Colston Budd Rogers & Kafes Pty Ltd

17 August 2022

RE: TRINITY GRAMMAR SCHOOL, SUMMER HILL
RESPONSE TO FURTHER MATTERS RAISED BY DPE
AND PUBLIC SUBMISSIONS

Figure 1

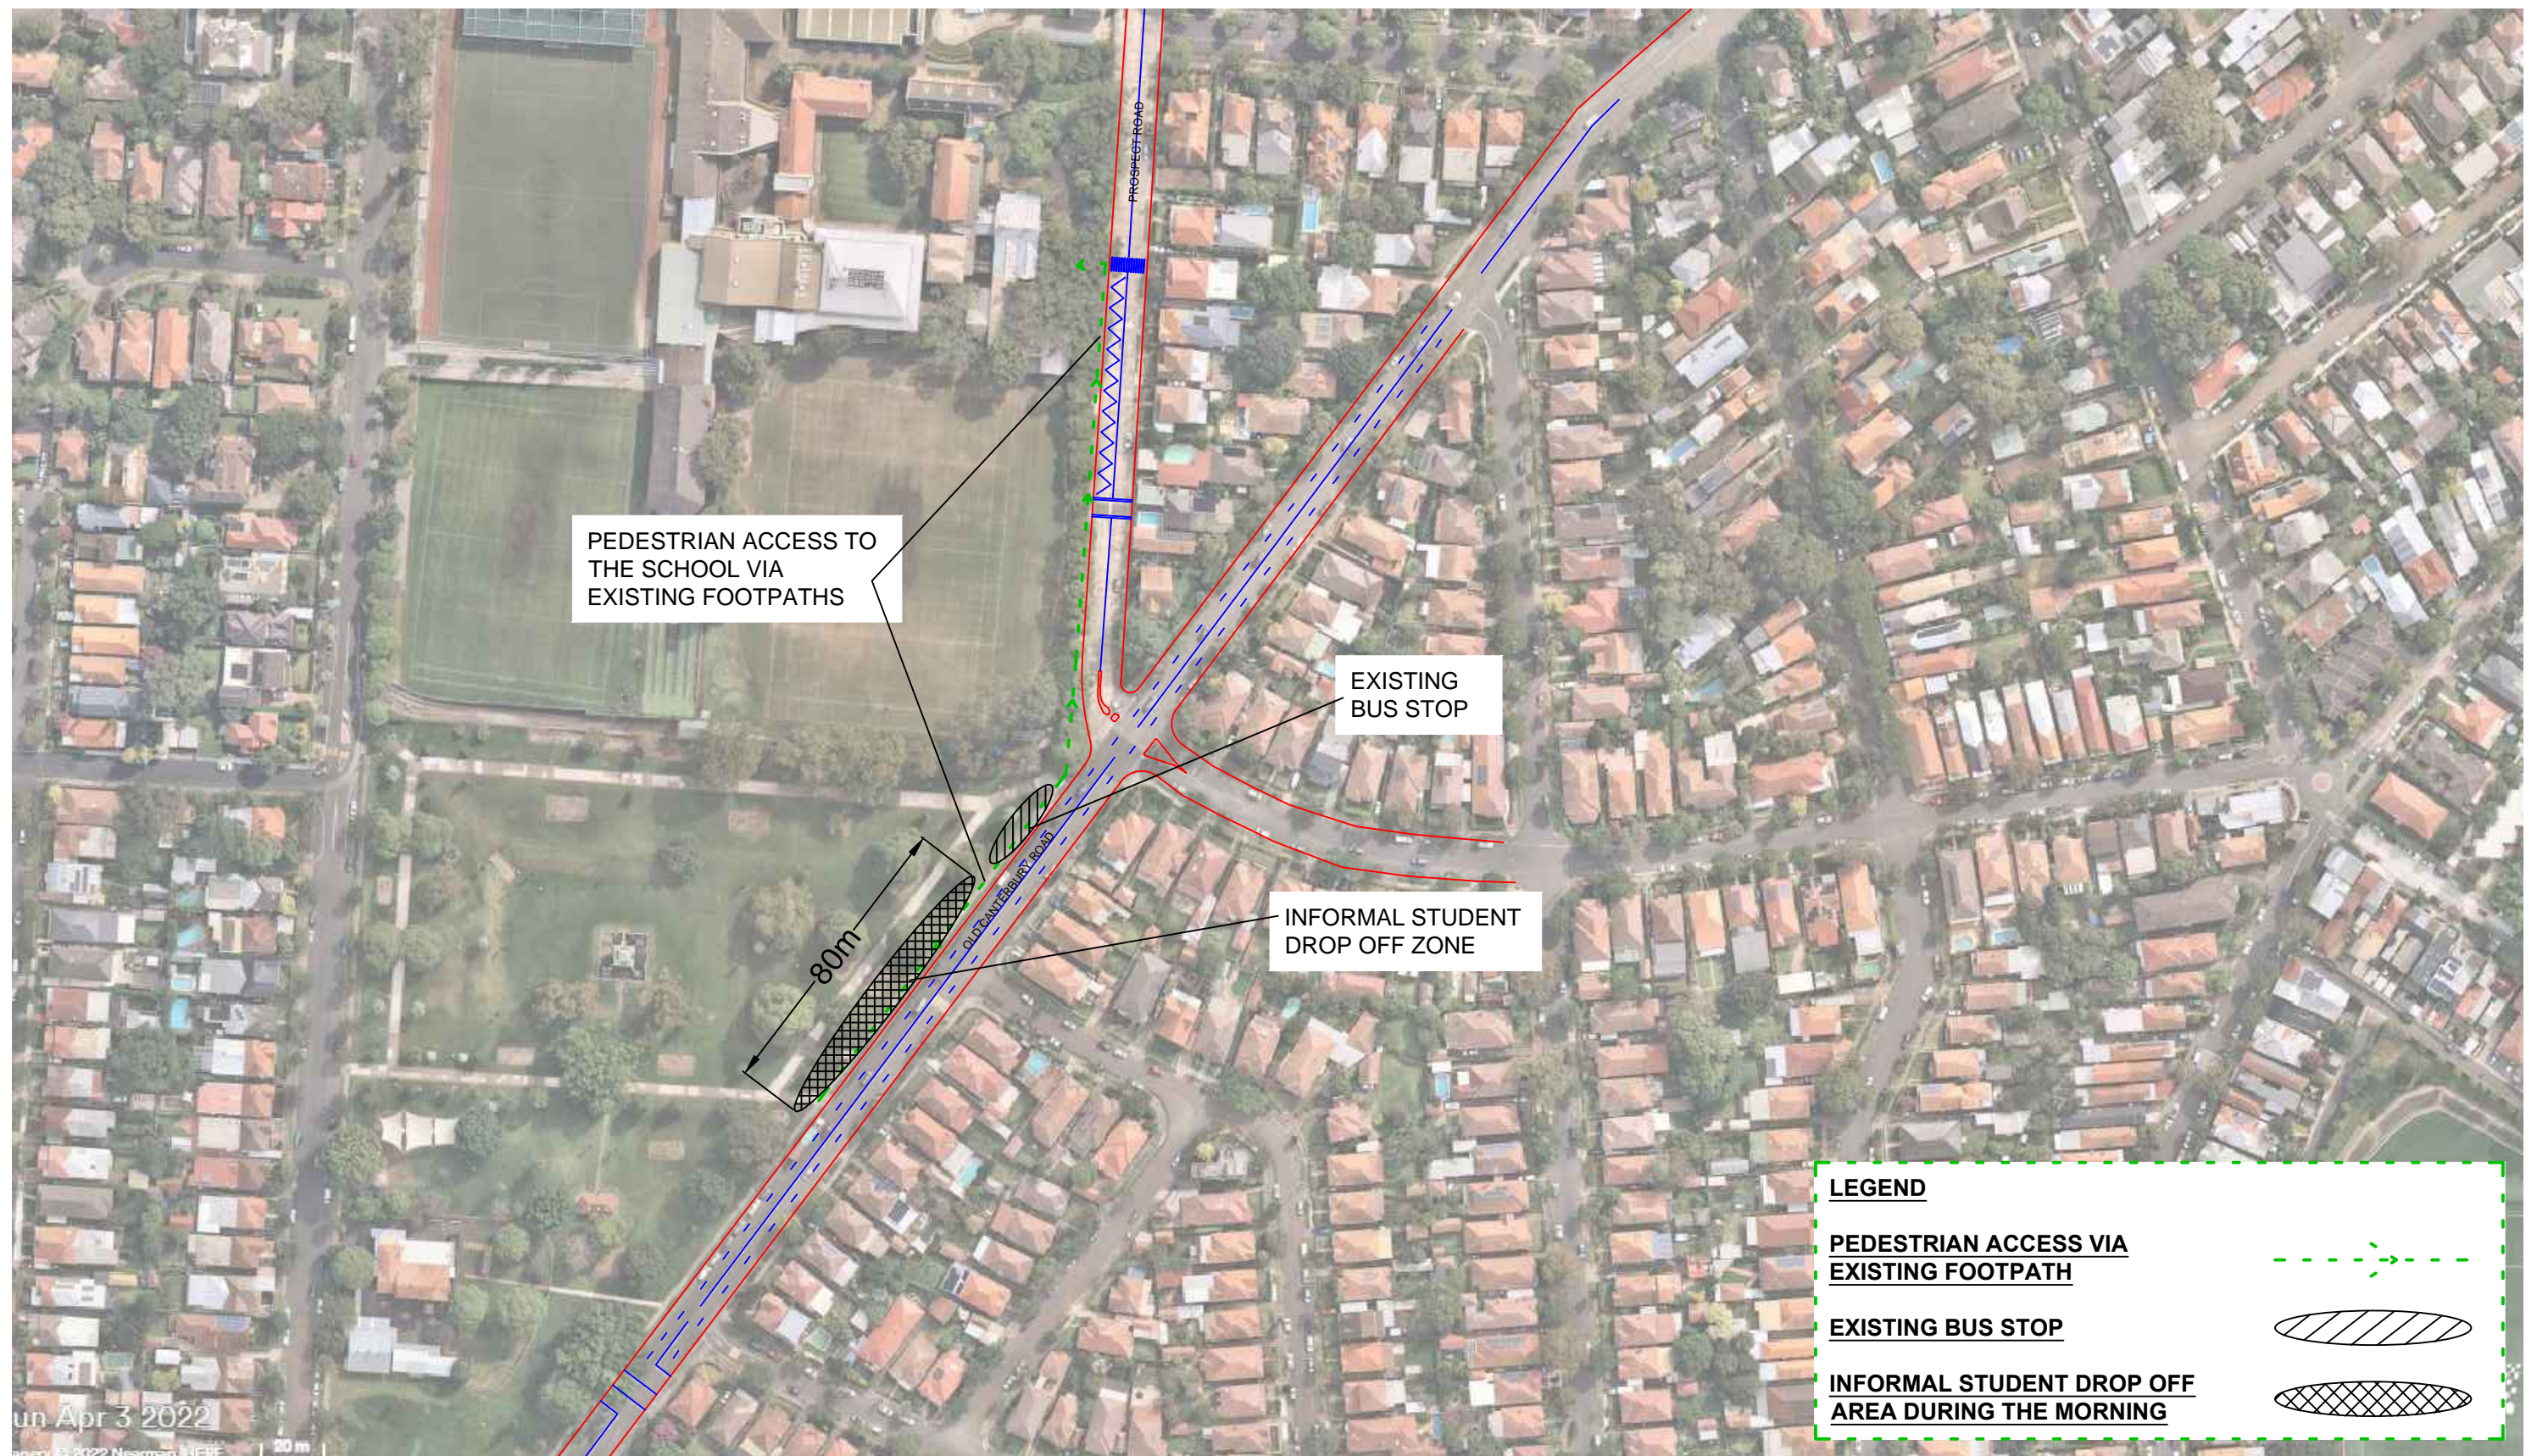
- *Inner West Council (Council) has reviewed the response to submissions report (RtS) and requested that you address the following:*
 - *Confirm whether the ‘informal’ drop-off zone on Old Canterbury Road would require appropriate signage to be placed to designate this area as a drop-off zone in the mornings and if required then identify what impacts that would have on the bus operational signage.*

- *Include consideration that additional approval/endorsement may likely be needed from the local traffic committee (or TfNSW) to install required signage (if any).*

5. These matters have previously been addressed in the attached CBRK letters dated 11 April, 10 June and 11 July 2022. With regards to Council's first point, the temporary student drop-off zone will be located on the northern side of Old Canterbury Road, adjacent to Yeo Park. It will be located to the west of the existing bus stop in Old Canterbury Road.

6. The zone will be a temporary informal zone to be used for the drop-off of students during the period of construction of the approved works. No signage or line marking is proposed for the temporary zone, with vehicles setting down students to occupy available on-street parking spaces within the kerbside lane of Old Canterbury Road. It will not impact on any Council/private land and will not affect any existing "No Stopping" zones, bus zones, parking zones, driveways or clearways along Old Canterbury Road.
